RE: **Lot 4 Block 3 Unit 22 Volcano Cliffs SAD 228**
6324 Camino Alto
Grading and Drainage Plan
Engineers Stamp Date: 8/4/2022 (D10D003R4)
Pad Certification Date: 2/14/2023
CO Certification Date: 1/18/2024

Based upon the information provided in your submittal received 1/19/2024, this plan for Certificate of Occupancy cannot be approved until the following comments are addressed.

ENGINEER'S SEAL  8/4/22	6324 CAMINO ALTO	DRAWN BY: WCVJ
	GRADING AND DRAINAGE PLAN	DATE: 8-04-22
 1606 CENTRAL AVENUE SE SUITE 201 ALBUQUERQUE, NM 87106 (505) 872-0999		20220055-LAYOUT-7-27-22
		SHEET #
		JOB # 20220055

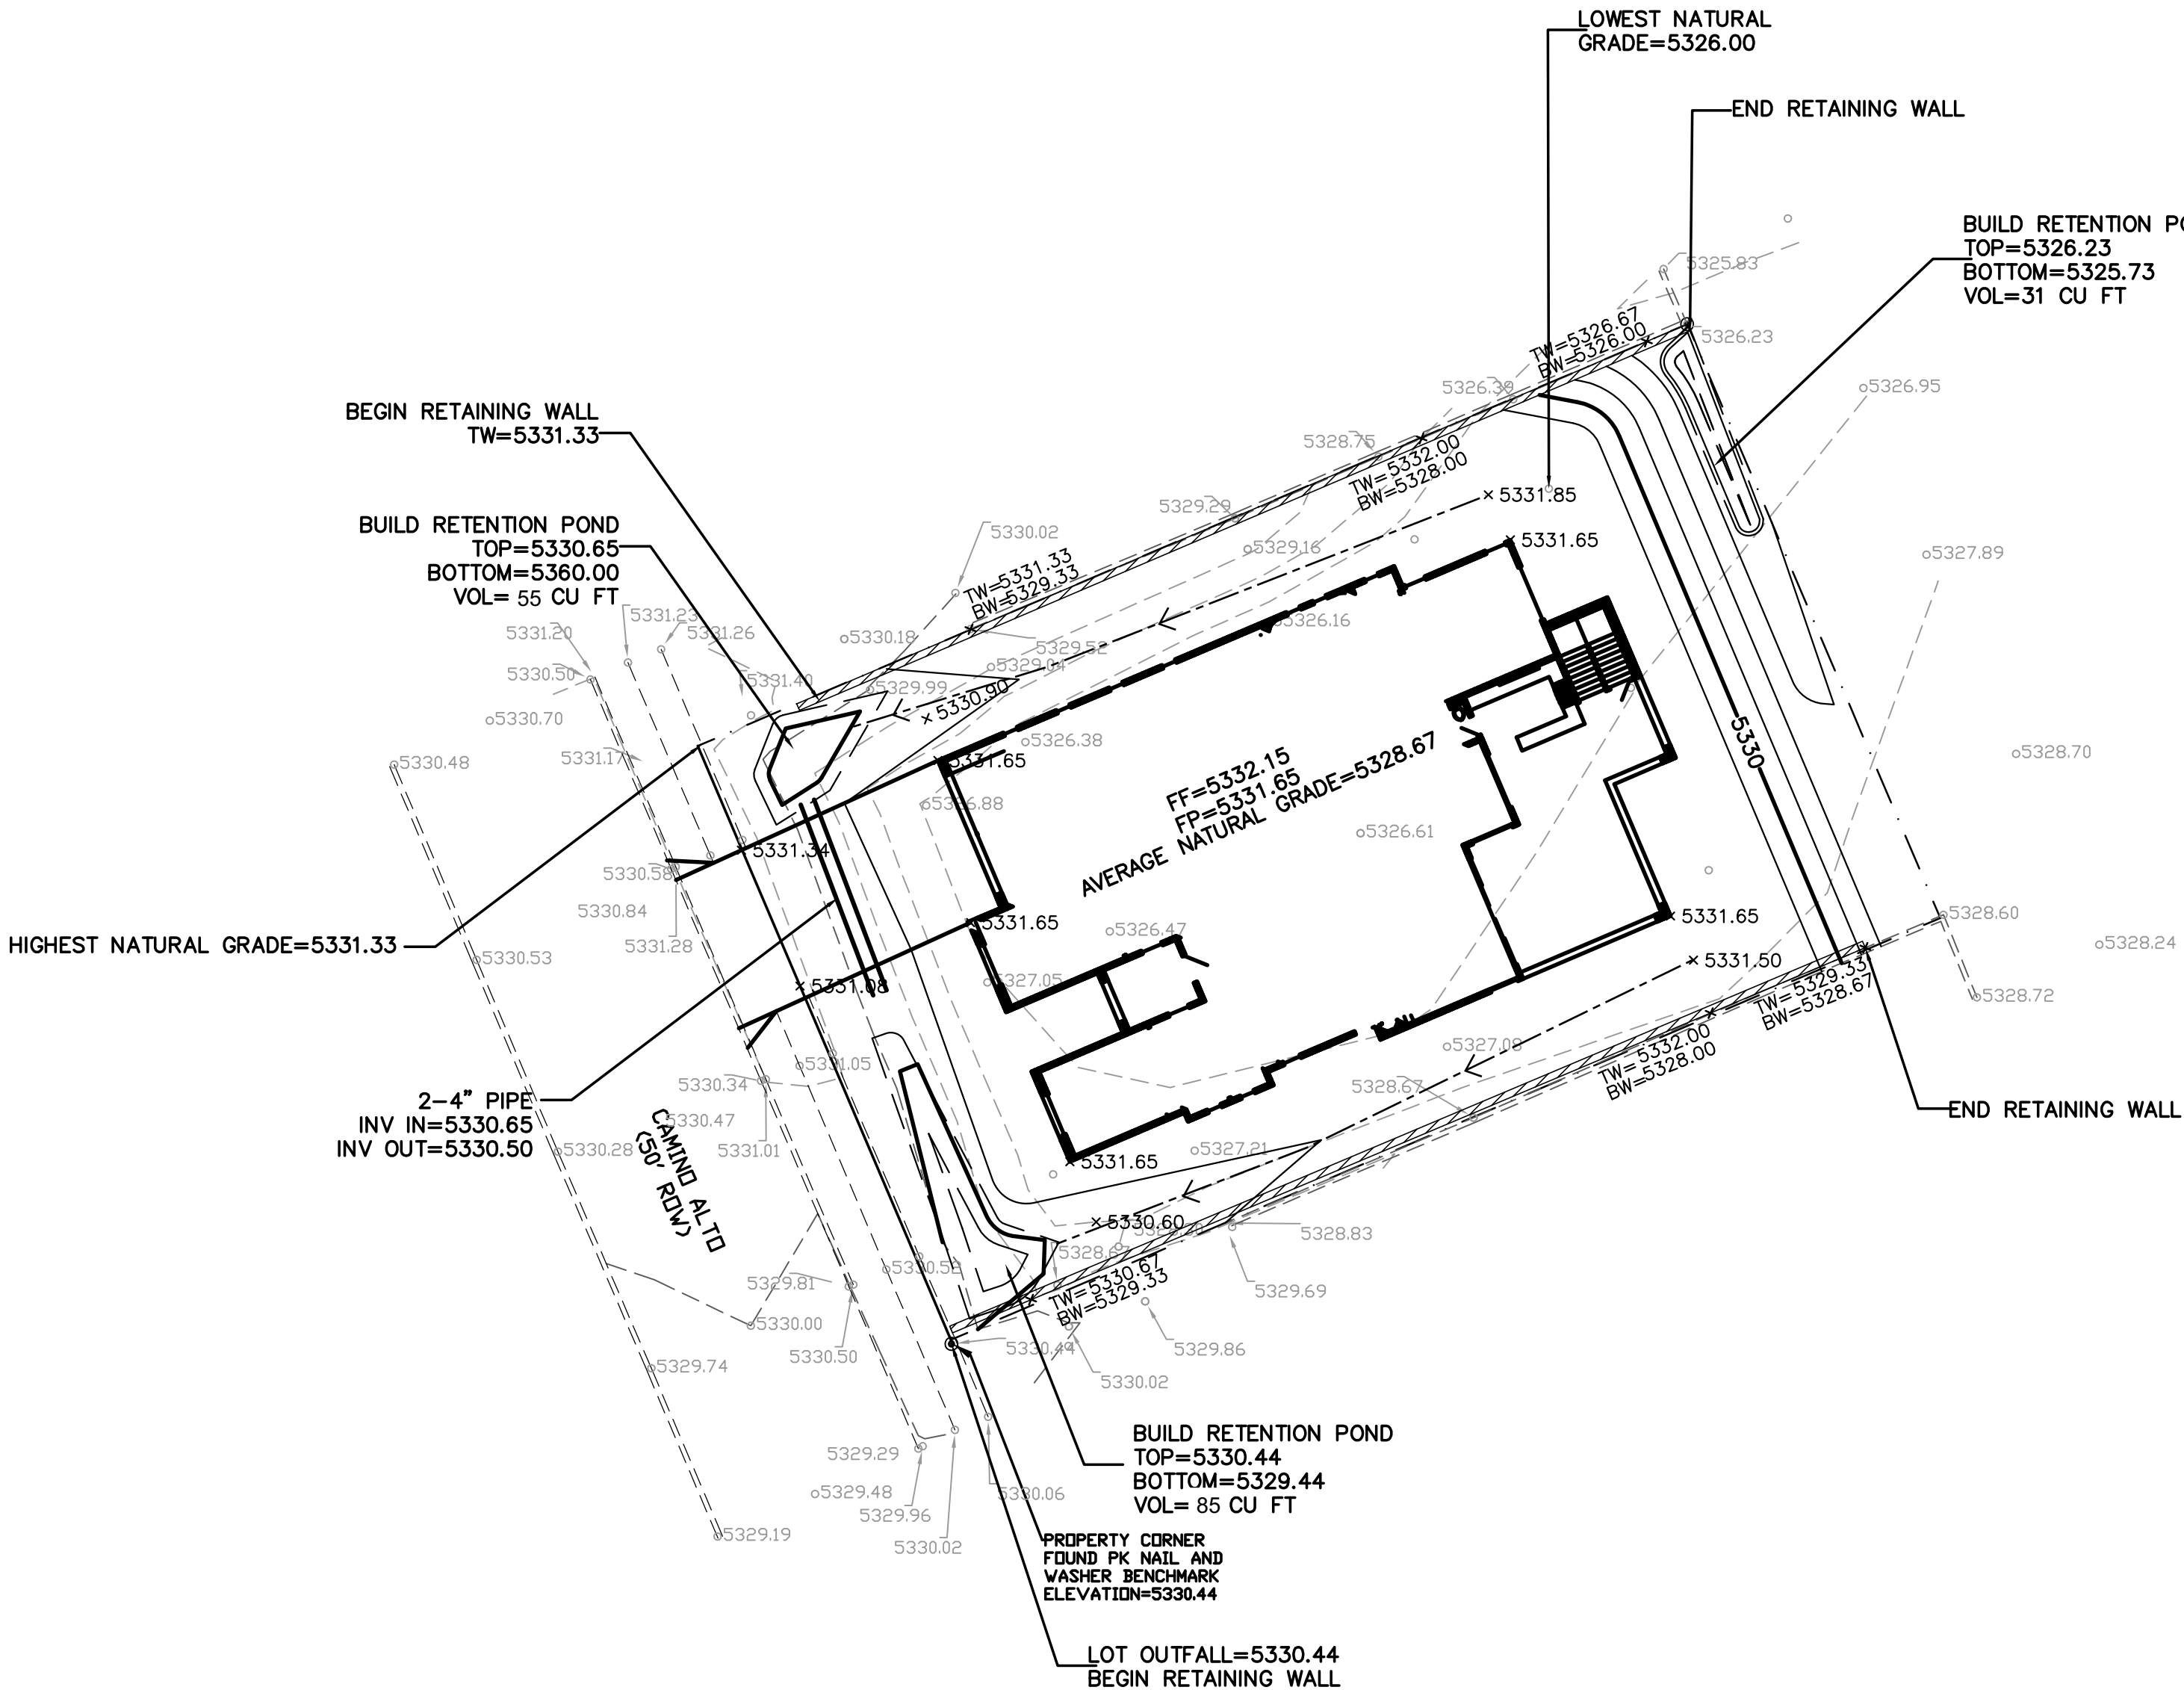
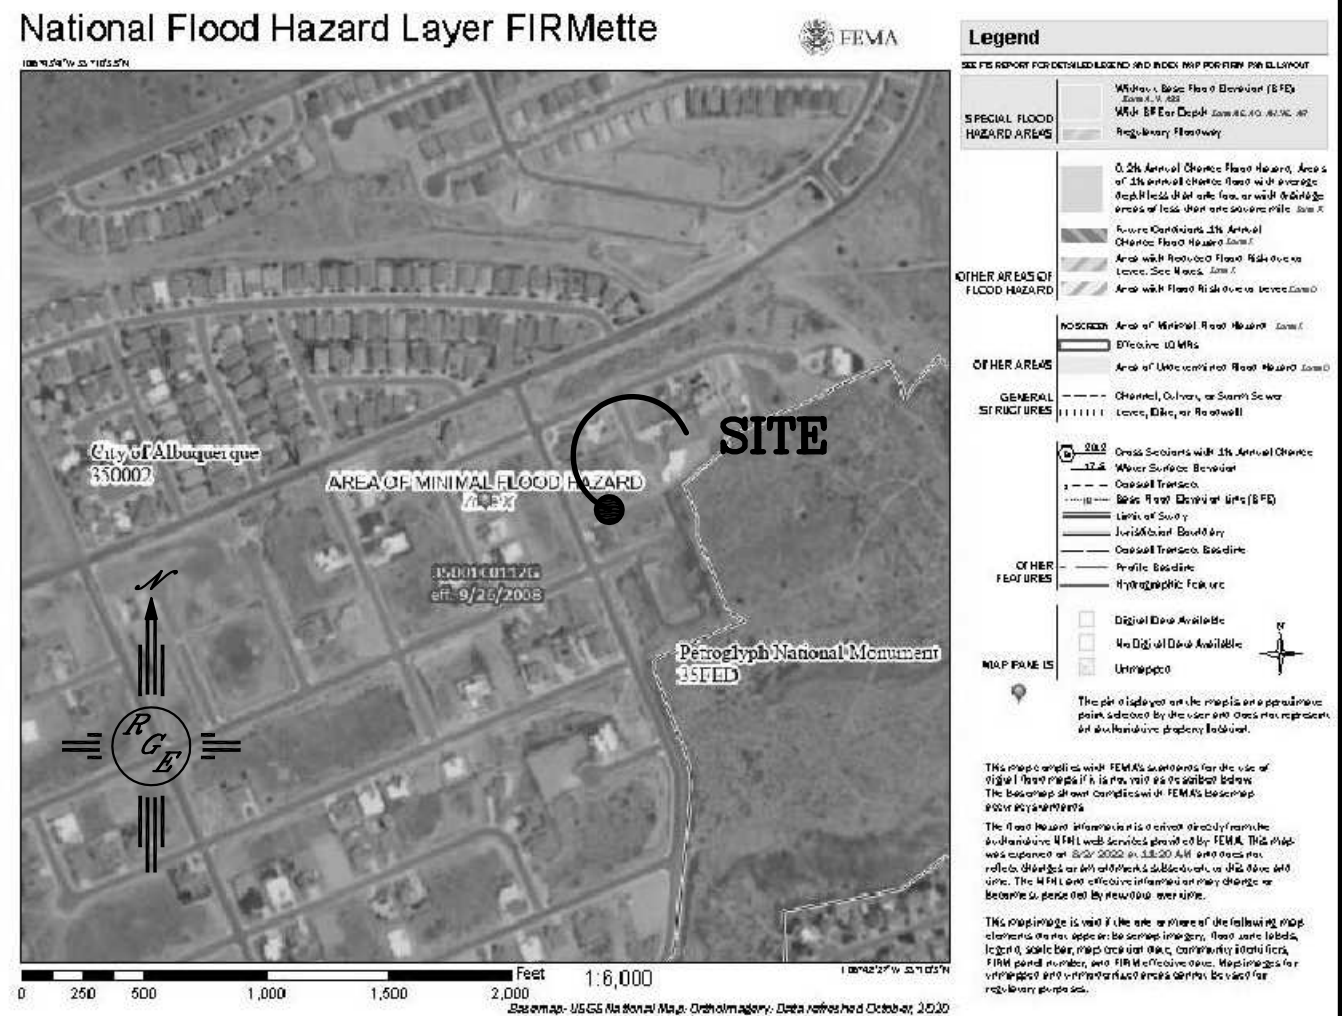
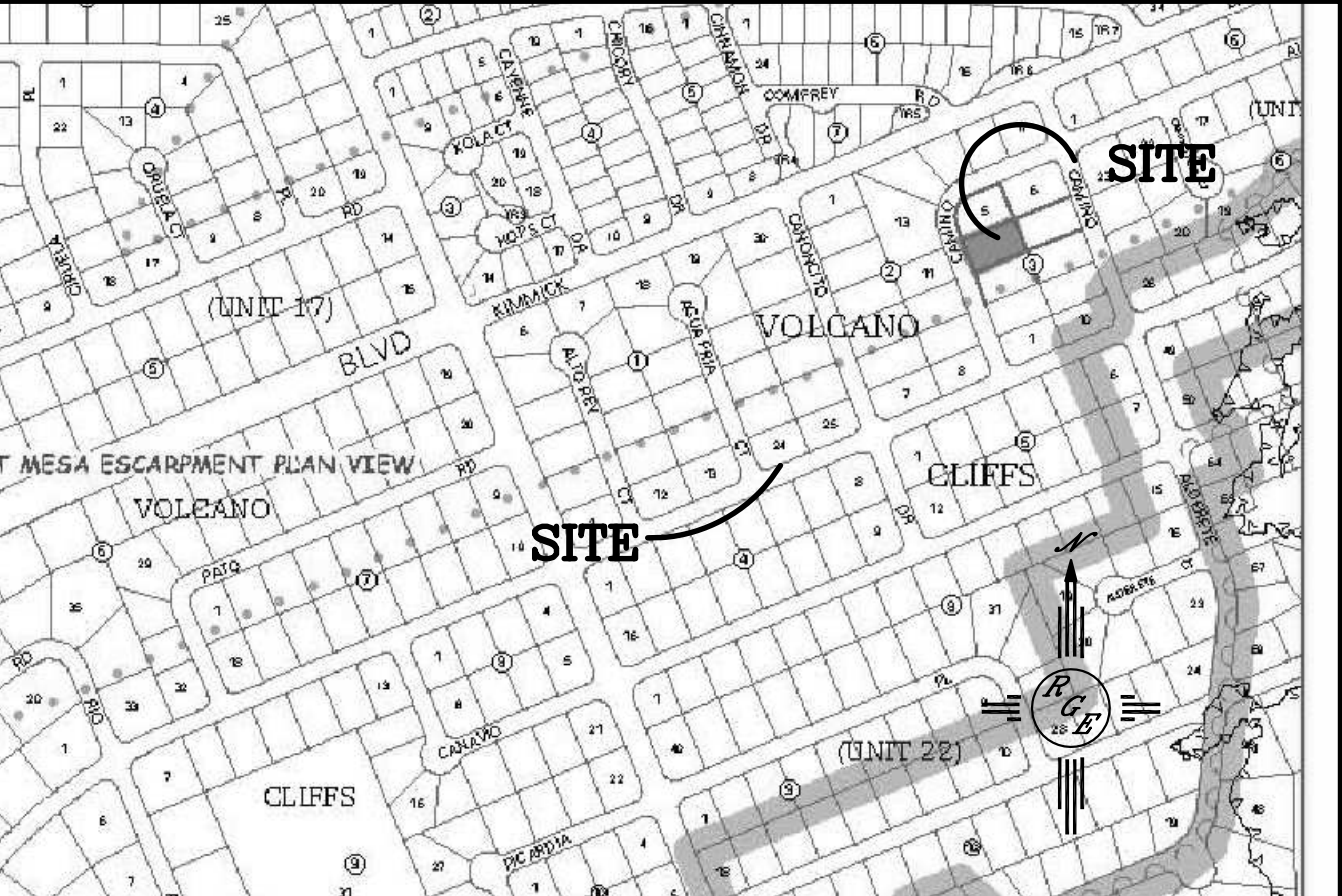
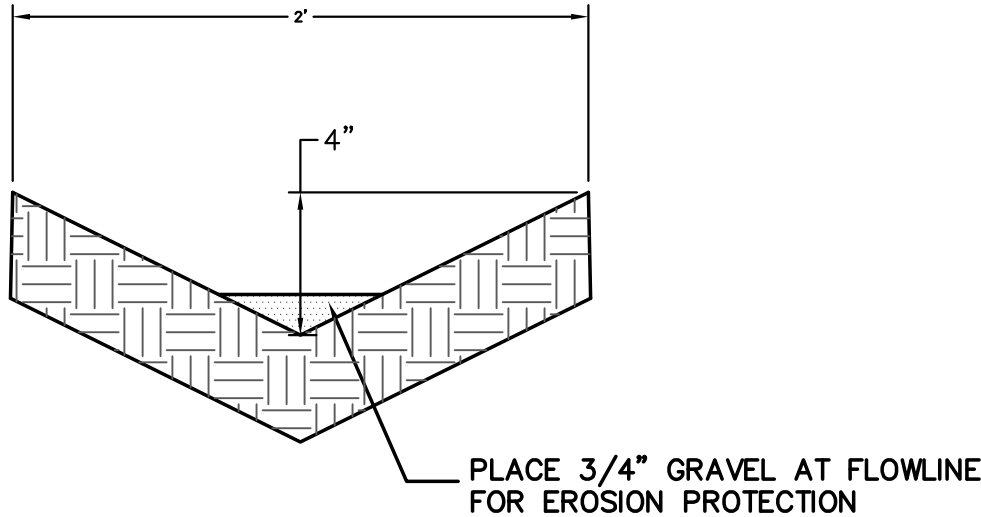
- Erosion protection must be provided in ponding areas.
- Provide erosion protection in all swales.
